**WEST SUSSEX COUNTY COUNCIL
PLANNING SERVICES CONSULTATION**

SUBJECT: WA/68/17/PL - Vehicular farm field entrance.

Land adjacent to The Meads, Barnham Lane, Barnham

Date	Drawn by	Scale
Sept 2017	CDP	as shown
Drawing No.	DP/A01	Revision
		02

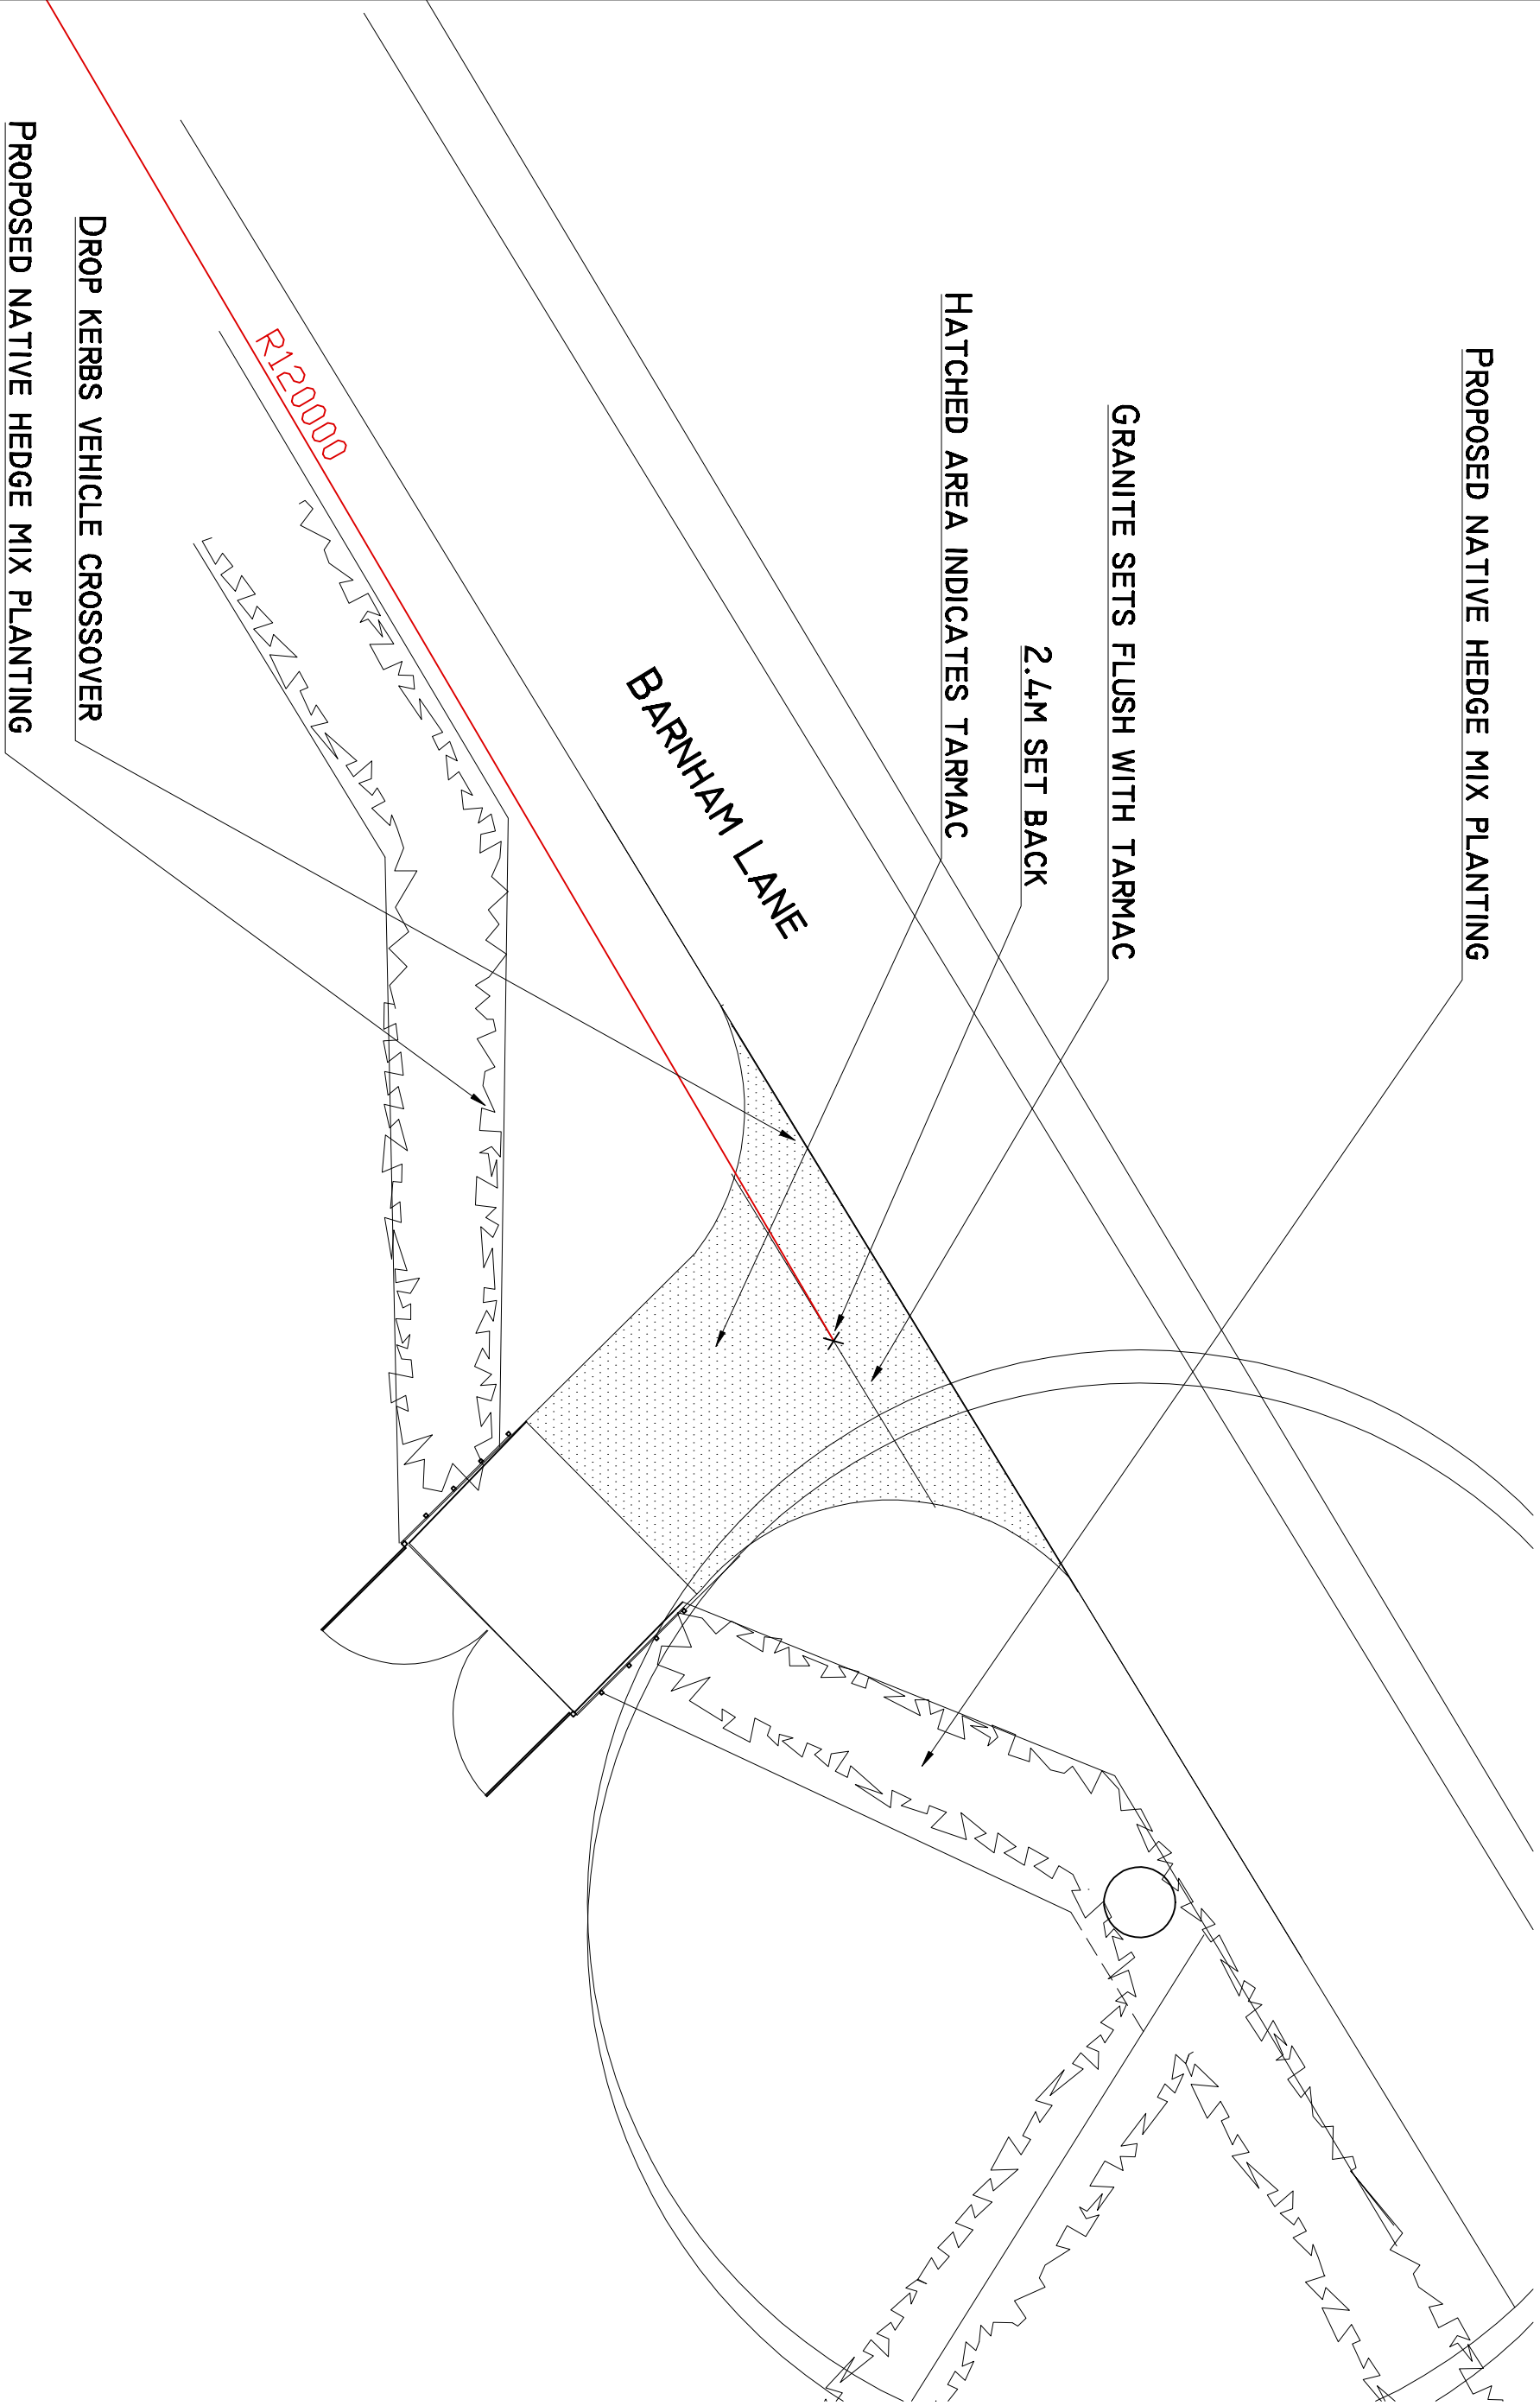
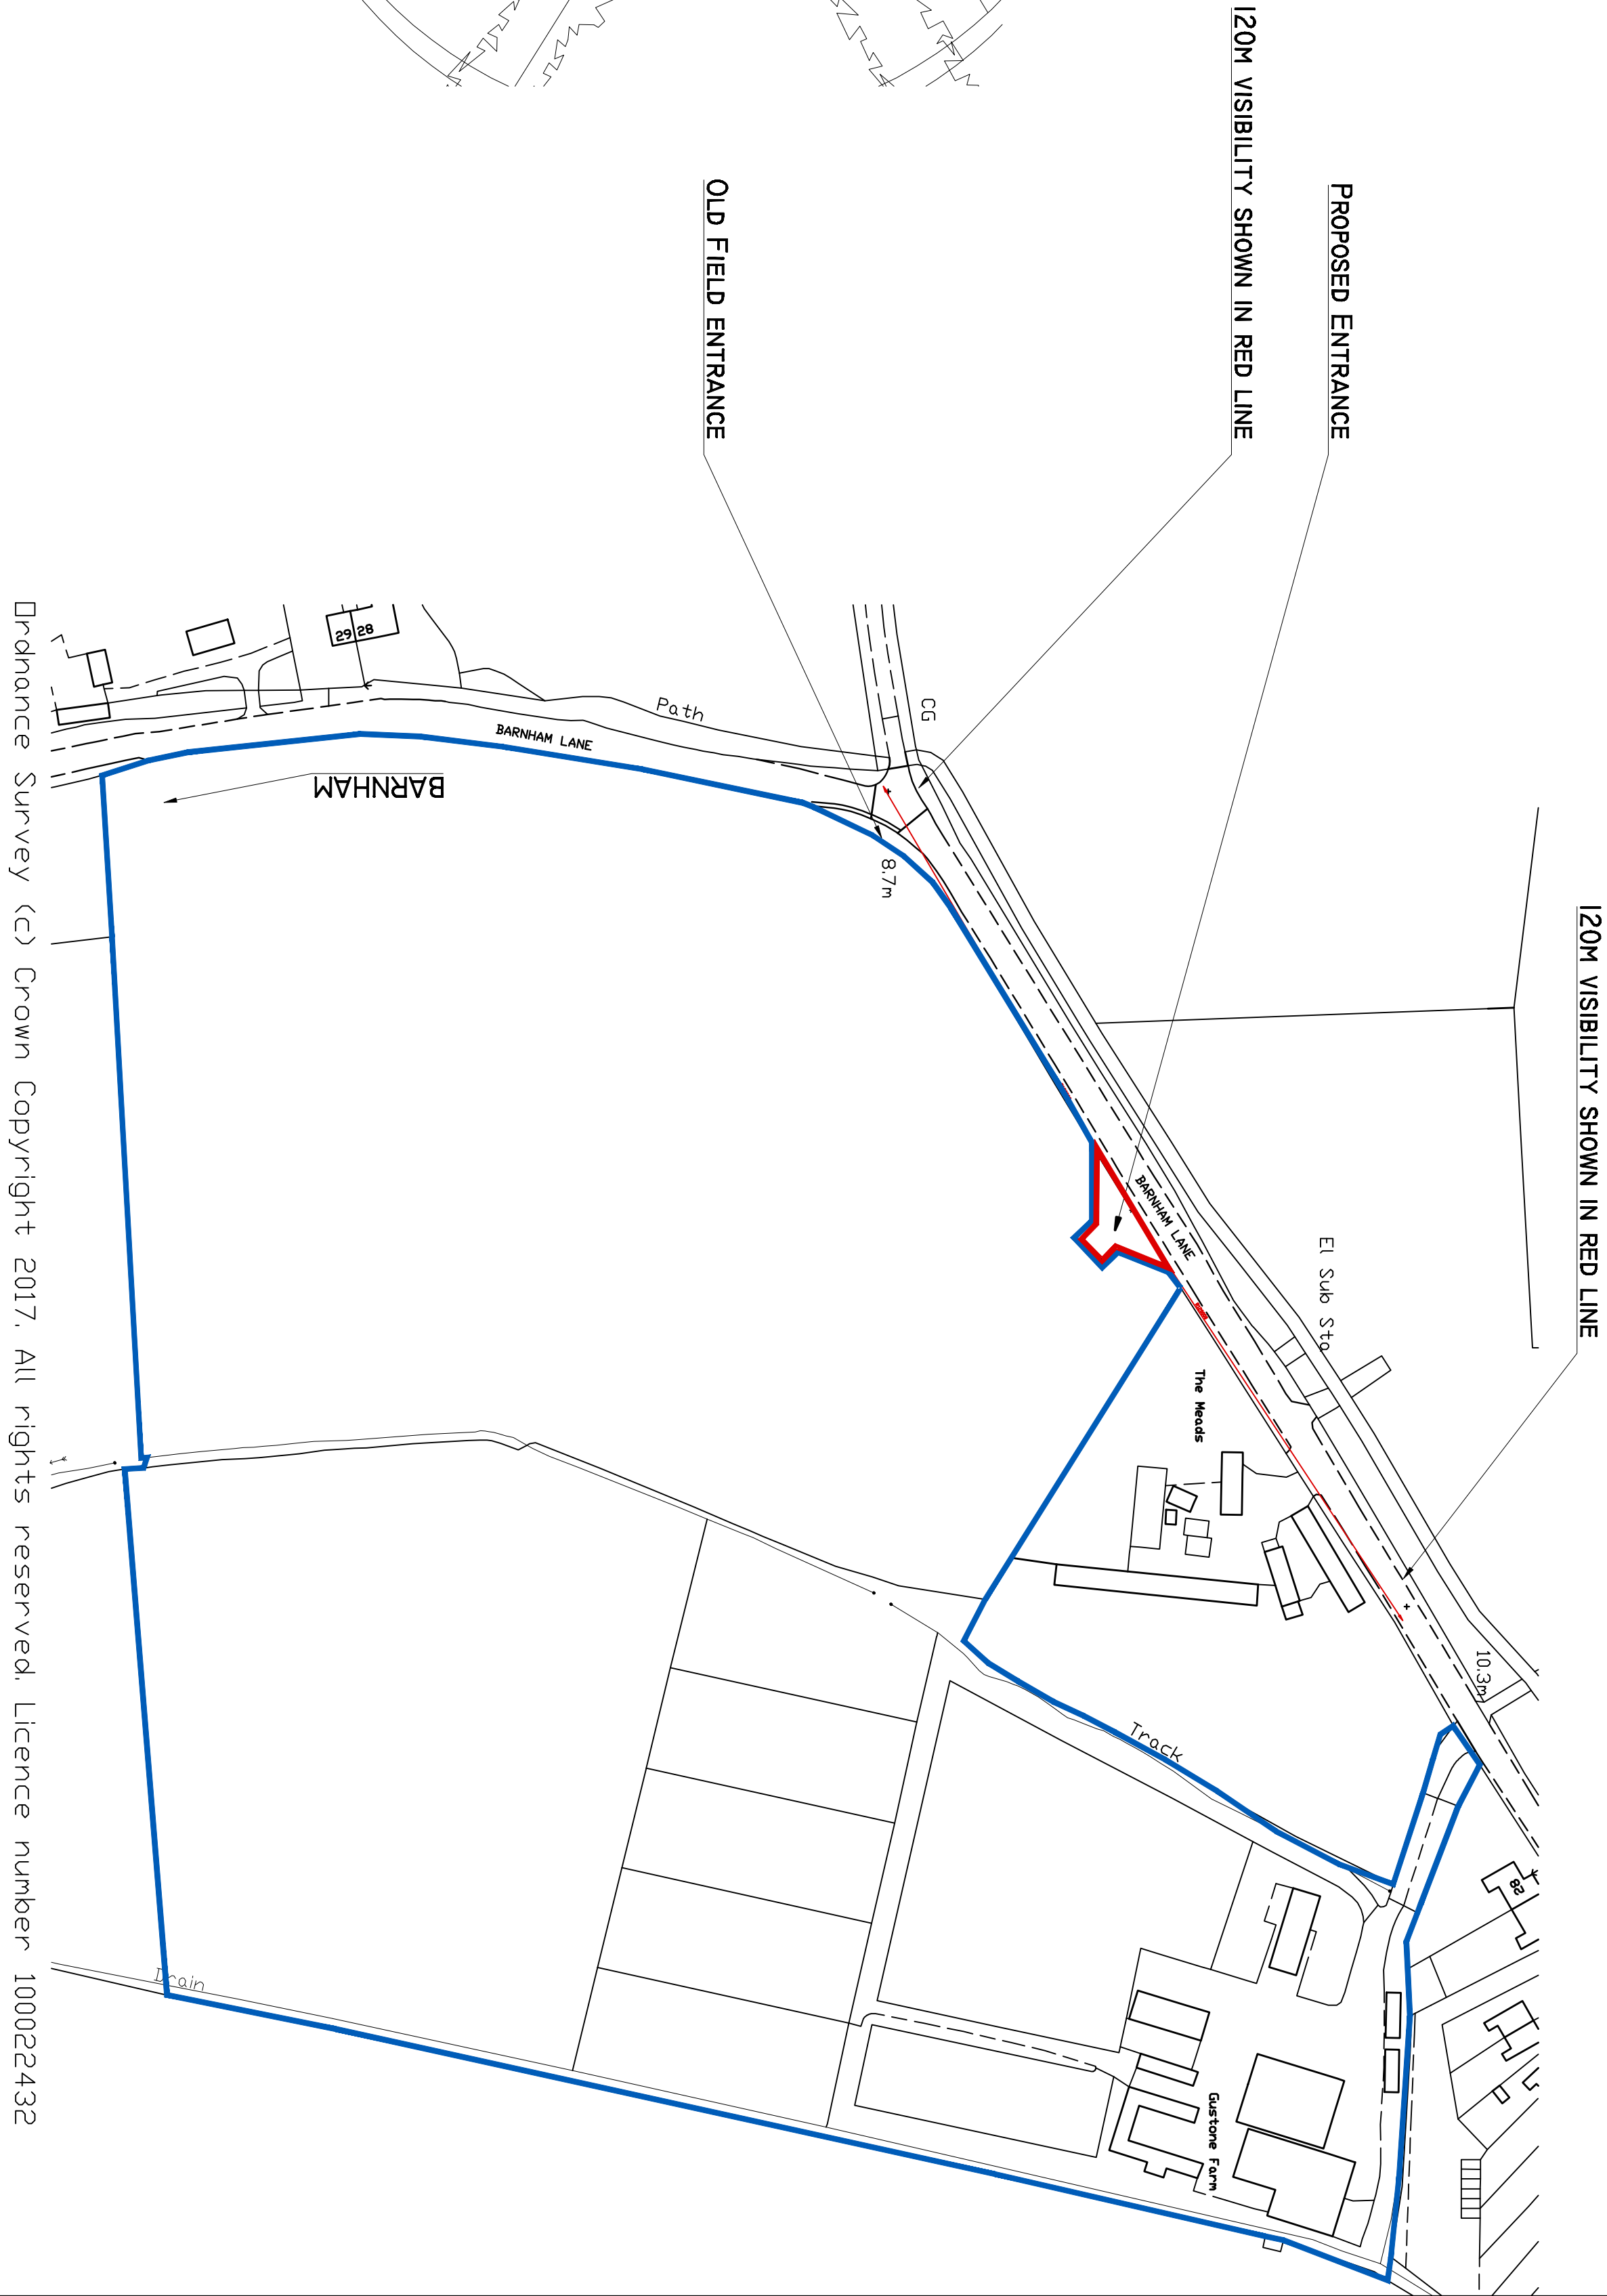
West Sussex County Council was consulted previously on Highway Matters for this application and provided a response dated 23/10/2017. More information was requested from the applicant to demonstrate appropriate visibility splays. Subsequently revised visibility splay plans have been provided, namely DPA-01 02 & DPA-02 01.

After review of the revised plans the applicant has satisfactorily demonstrated that 2.4 x 120 metre visibility splays are achievable using land under their control or that considered to be public highway. Such splays would be considered acceptable for the design speed of Barnham Lane at this point as per the Design Manual for Roads and Bridges (TD/9/93). The Local Planning Authority should be aware that the formation of these splays will have an impact on the adjoining boundary hedging.

The use of the access point shall not commence until visibility splays of 2.4 metres by 120 metres have been provided at the proposed site vehicular access onto Barnham Lane in accordance with the approved planning drawings. Once provided the splays shall thereafter be maintained and kept free of all obstructions over a height of 0.6 metre above adjoining carriageway level or as otherwise agreed.
